Development Facilitation Team (DFT) – Review Comments

Project No: PR-2019-002089

Application For: SD-2023-00196-PRELIMINARY/FINAL PLAT (DHO)

Project Name: 239 - 243 Anna Maria Pl SW

SKETCH PLAT OF  
 LOT 19A-P1-A  
 SUNSET FARM SUBDIVISION  
 UNIT 2  
 SITUATE WITHIN  
 PROJECTED SECTION 24, T. 10 N., R. 2 E., N.M.P.M.  
 TOWN OF ATRISCO GRANT  
 CITY OF ALBUQUERQUE  
 BERNALILLO COUNTY, NEW MEXICO  
 JULY 2022

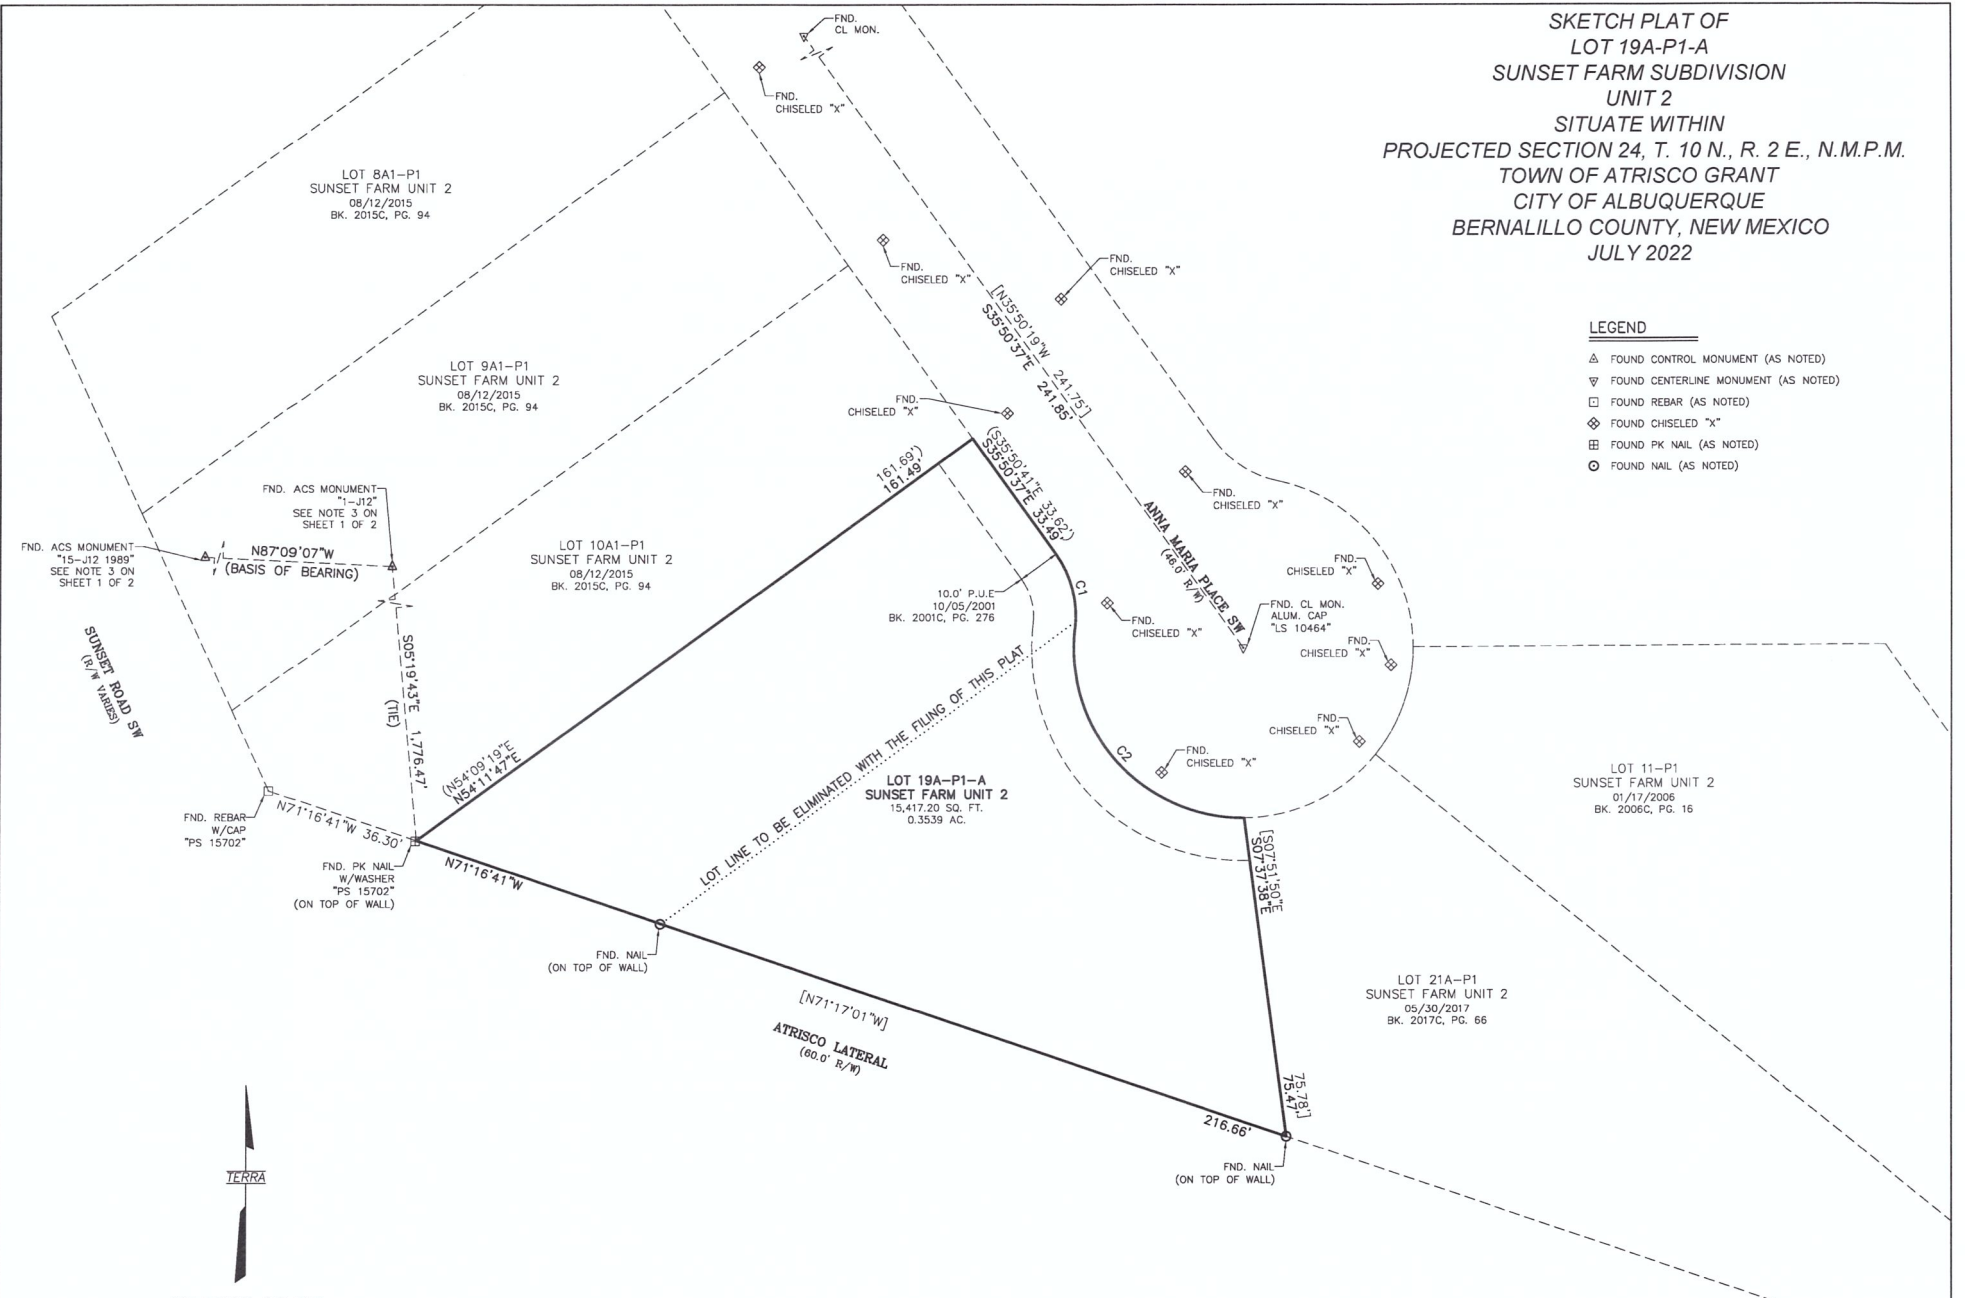
1. Variances to the required Contextual Lot size for combining 239 and 243 Anna Maria have been obtained, VA-2023-00098 and VA-2023-00099, addressing our primary concern.
2. Code Enforcement recommends that a note on the plat is added indicating the Variances were obtained.
3. Code Enforcement has no further comments and no objections.

4. Property owner has obtained the required Variances for the Contextual lot size for both lots, as per documentation provided in the submittal.
5. A note should be added to the plat regarding the Variances obtained, and citing Variance case numbers.

6. Minimum lot size allowed, at 75% of 0.1825 acre = 0.1369 acre
7. Maximum lot size allowed, at 150% of 0.1825 acre = 0.2738 acre
8. Proposed combined lot size is 0.3539 acre, which exceeds the allowed size. Prior to replat, you must obtain a Variance for the difference above the allowed lot size (.3539 acre - .2738 acre = **.0801 acre variance**), as per IDO section 5-1(C)(2)(b)(3).

1. Transportation is satisfied with the plat showing Anna Maria is Private. No objection.
